Project Name: *Cherry Hills Unit 1*

RE: Request for Final Sign-Off for Southwest Federal Credit Union

On behalf of the applicants, we request a final DRB sign-off for the property legally described as. On June 10, 2010, the Environmental Planning Commission conditionally approved a Site Development Plan for Building Permit. This document outlines how each EPC condition has been met. Conditions are in normal text; *applicant responses are italicized.*

On June 10, 2010 the Environmental Planning Commission voted to approve Project 1008147/10EPC-40026, a Site Development Plan for Building Permit, for Tract C1A4A Cherry Hills Unit 1, based on 13 Findings and subject to the following Conditions:

1 DOUBLE FACE MONUMENT SIGN
A-301 NOT TO SCALE

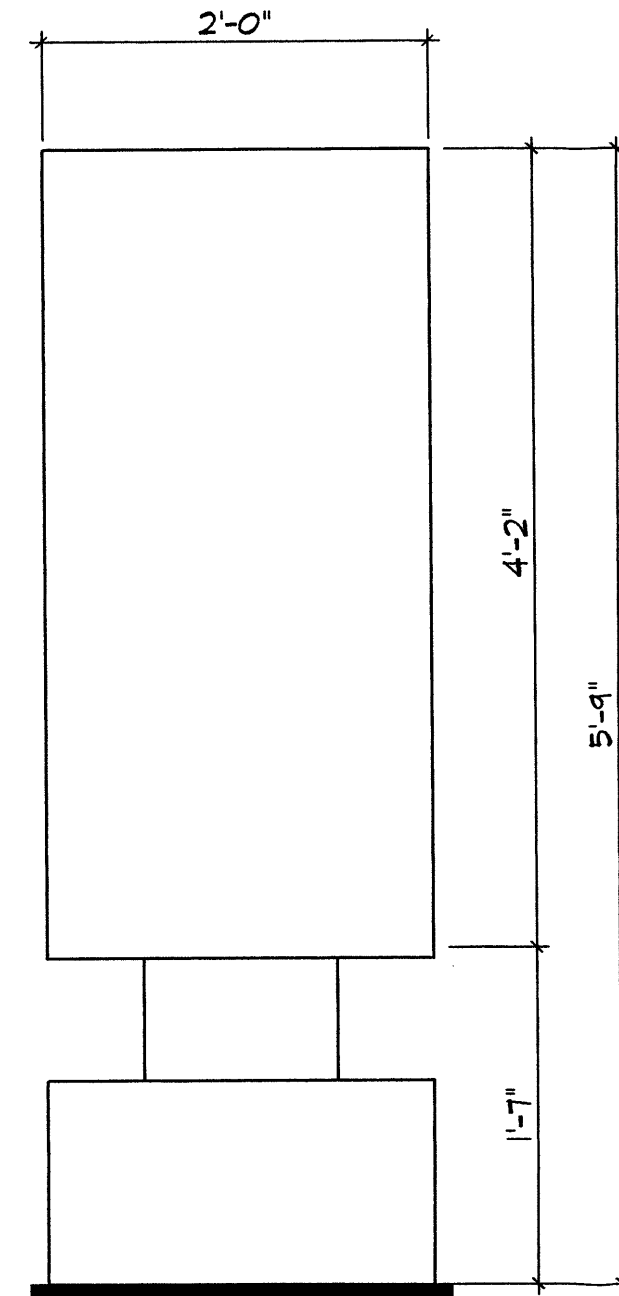
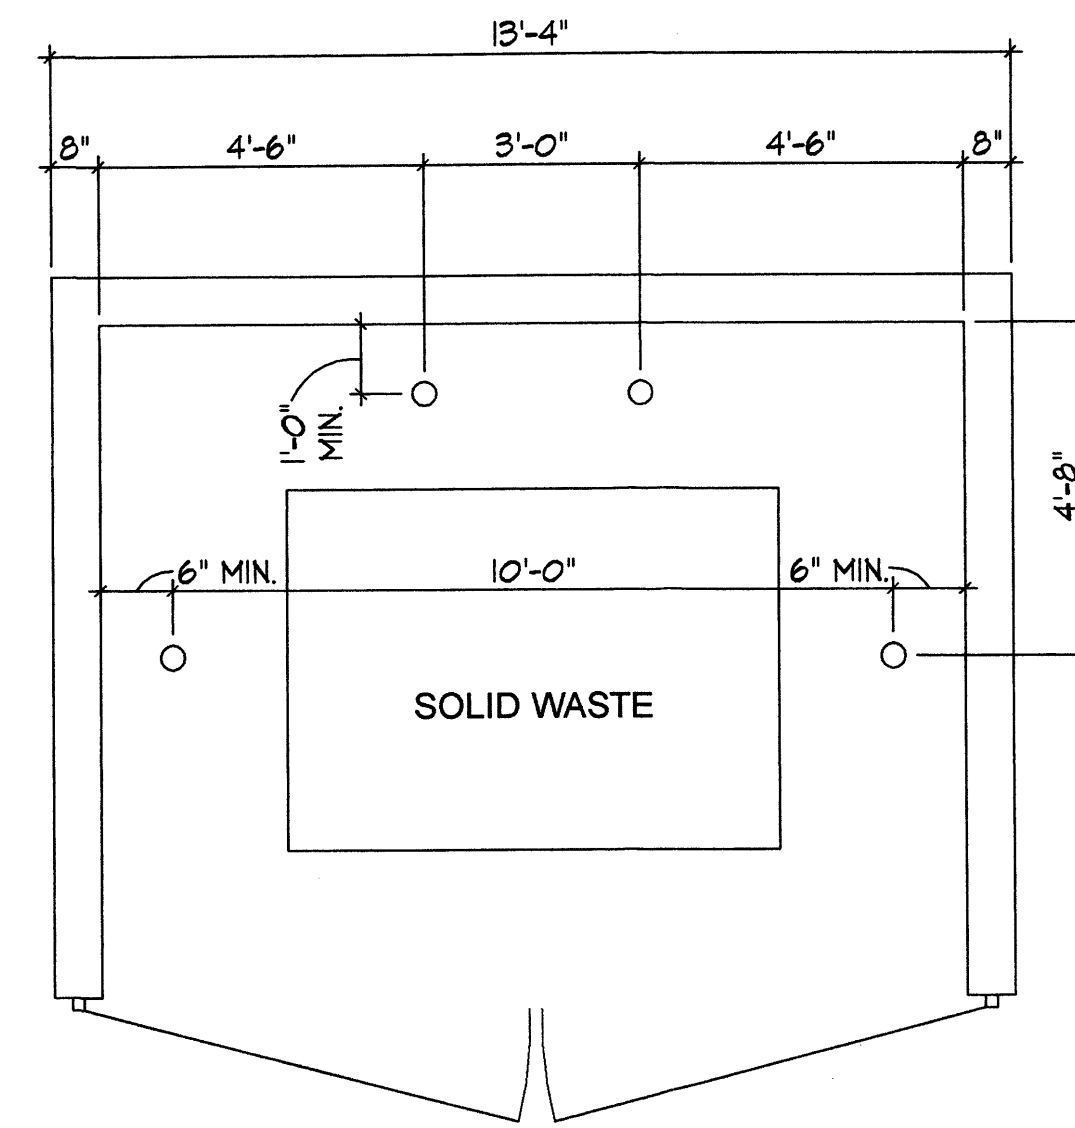
- c. The monument sign shall be redesigned to consist of individual letters. Illumination shall comply with area lighting and general sign regulations in the Zoning Code.

The monument sign has been redesigned to comply with this condition.

4 WALL/POLE LIGHTING DETAIL (NEW)
A-301 NOT TO SCALE

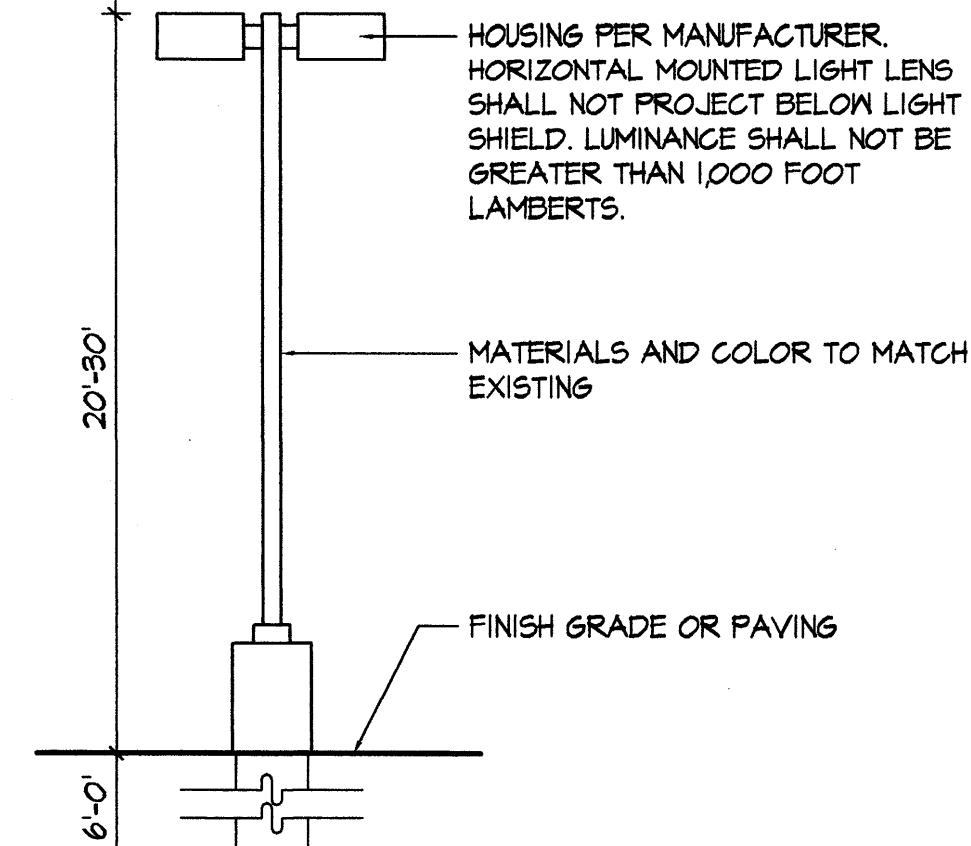
- c. A typical building-mounted light shall be called out on sheet 5 of the elevations.
A detail for the wall mounted light fixture was added to sheet 5 and the specific locations for the wall mounted lights identified.
